Scheme Title	Dewsbury Riverside - High
Job No.	48206
Doc Ref.	
Revision	
Date	27/07/2023

Highway Drainage Proposals

Cultural Heart Project - Preliminary Design com

Design Reviewer comments (Kirklees)

Client: **KIRKLEES COUNCIL**
 Architect: **BARTON WILLMORE**
 Project: **DEWSBURY RIVERSIDE**
 Dwg Title: **HIGHWAYS PHASE 1 HIGHWAYS DRAINAGE SHEET 3**

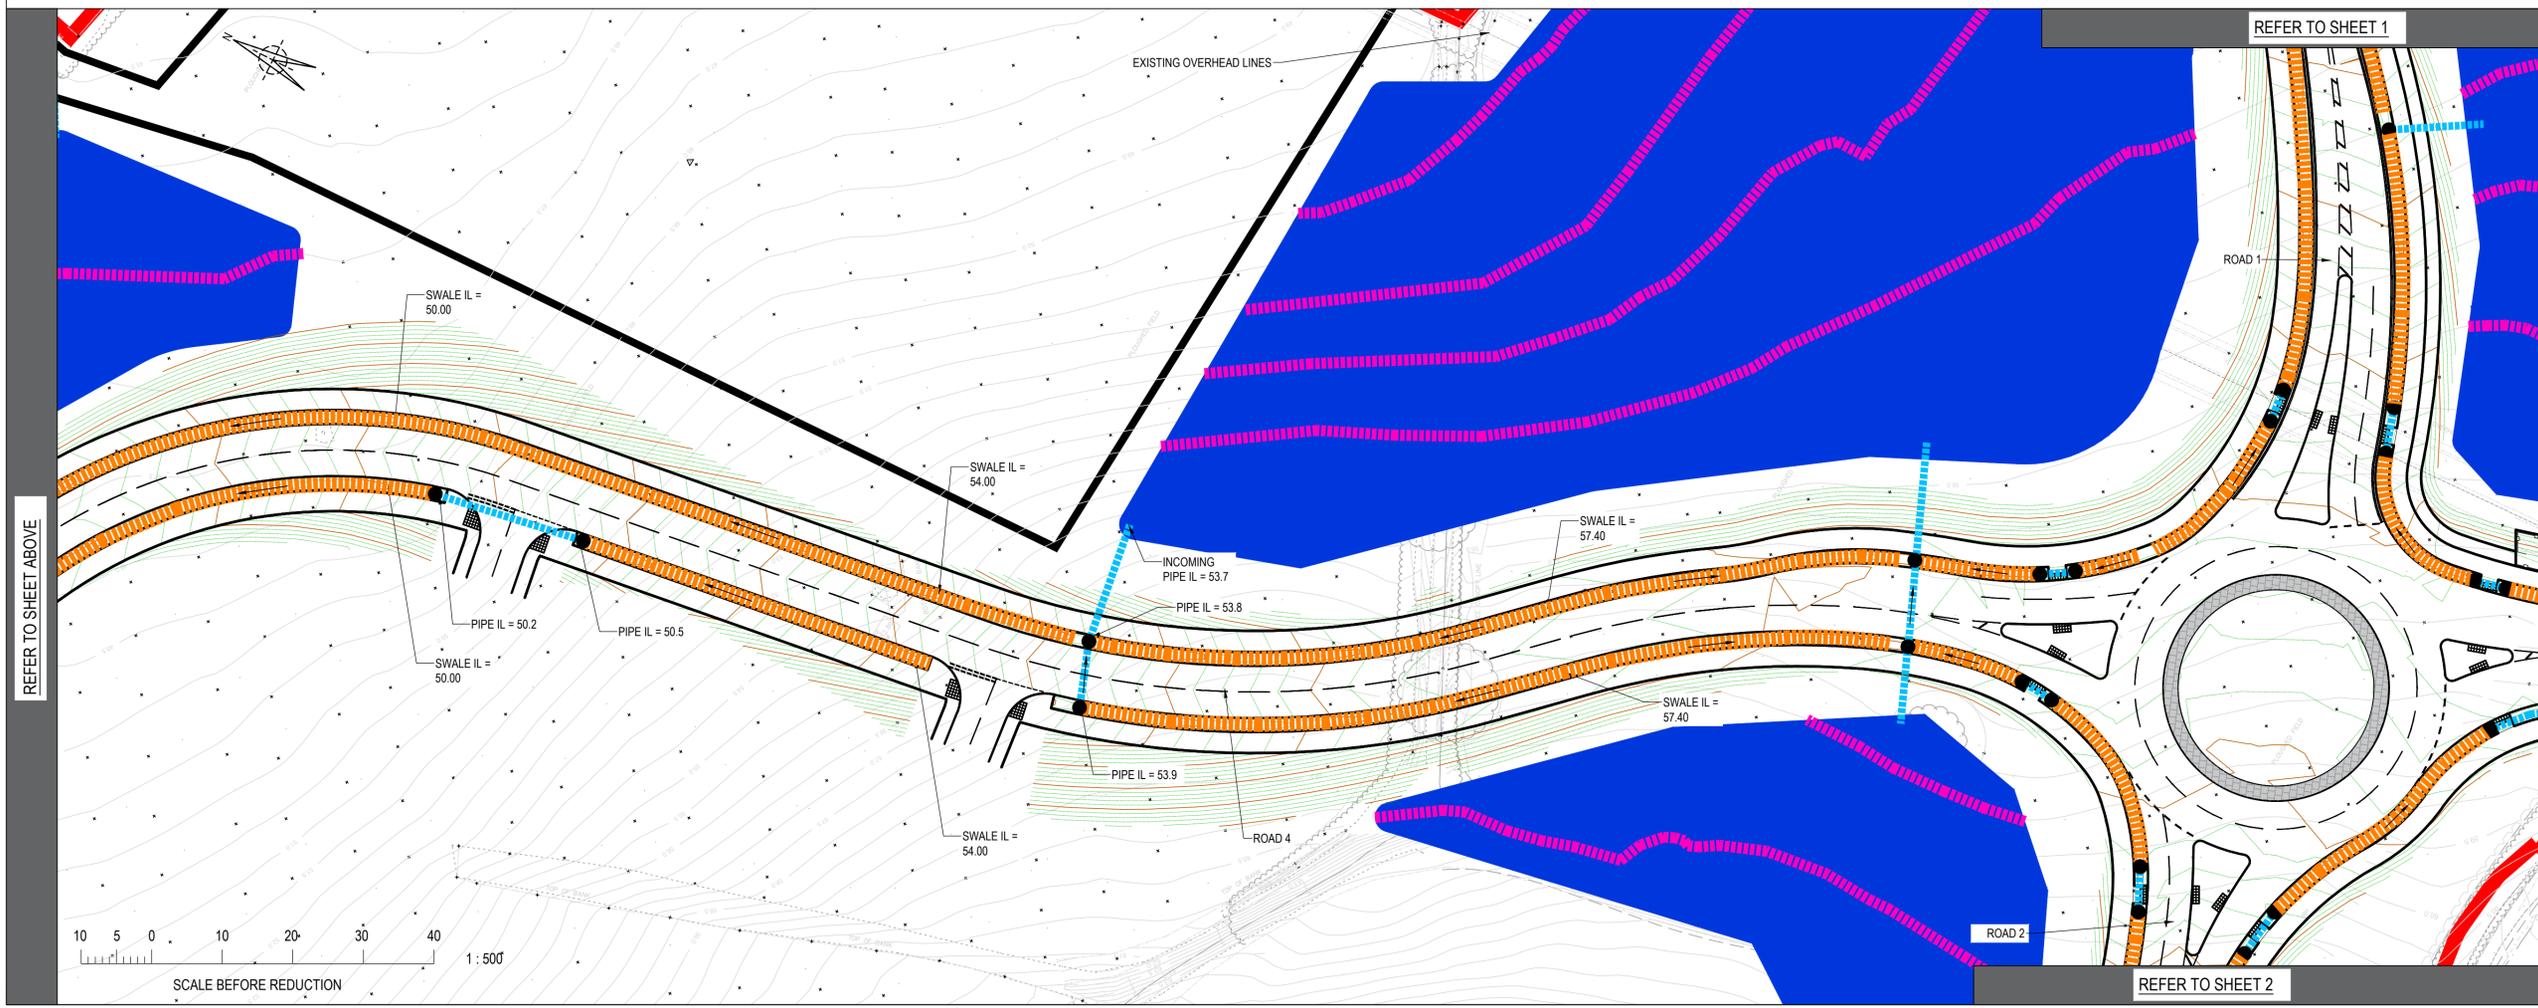
No Drawing Number within the Drawing Frame.
Apply the Standard Drawing Name Convention to include an appropriate drawing Number for future reference.

The Buro Happold Drawing Frames do not include a dates within the drawing for creation, checking and approval within the main body of the frame. Confirm the drawing frame satisfied the Standards for Drawing Frames.

Indicate the project chainage on the drawings. It will make identification of issues easier.

Review and amend the proposed lengths for Gully Connections.
Shorten the gully connections to 12 metres maximum.

Designer to provide calculations for Gully Spacing in accordance with CD 526 - Spacing of Road Gullies to confirm frequency of proposals during detailed Design Stage.

Designer shall review the proposed surface water collection to the Forge Lane / Ravensthorpe Road Junction. Compliance with CD 526 and confirmation of any drainage requirements to the footway / cycleway area during detailed design stage.

Private (Non-Highway Drainage is indicated being discharged into the Adopted / Highway Drainage System. This is not permitted. See the requirements within the Kirklees Council "Highways Guidance Note - Highways, SuDS, and Private Drainage".

Designer to indicate the proposed drainage to what appears to be a parking area within the Turning Head to the No through Road section of Ravensthorpe Road. No drainage is indicated.

Designer to review the proposals to the gully positions to the revisions to the original No-through road section of Ravensthorpe Road. The proposed gully positions to not appear to suit the low points/ revisions to the kerb line.

Designer to review the proposals to the gully positions to the Ravensthorpe Road (Through Road Section). Where the kerb line is revised to remove existing parking bays, the gully positions will need to be revised.

Reconsider the Location of the Chamber connection to the existing drainage network. This is located to the centre of the carriageway. This would require the full closure of the carriageway to Access / Open / Maintain. Offset to one side of the carriageway.

Demonstrate how the surface water from the roundabout approached / circulatory carriageway enters into the adjacent swales. No Detail is proposed.

Designer to reconsider the location of gullies at the dropped crossings tot eh Ravensthorpe Road Junction. The Gullies are within the dropped crossing.

Designer to demonstrate how the assumed Invert Level of 40.25AOD was determined as the invert for the existing drain.

Drawing Key / Annotation indicates Check Dams on Attenuation Basins. Designer to confirm if these are proposed, as it is not clear from the drawing.
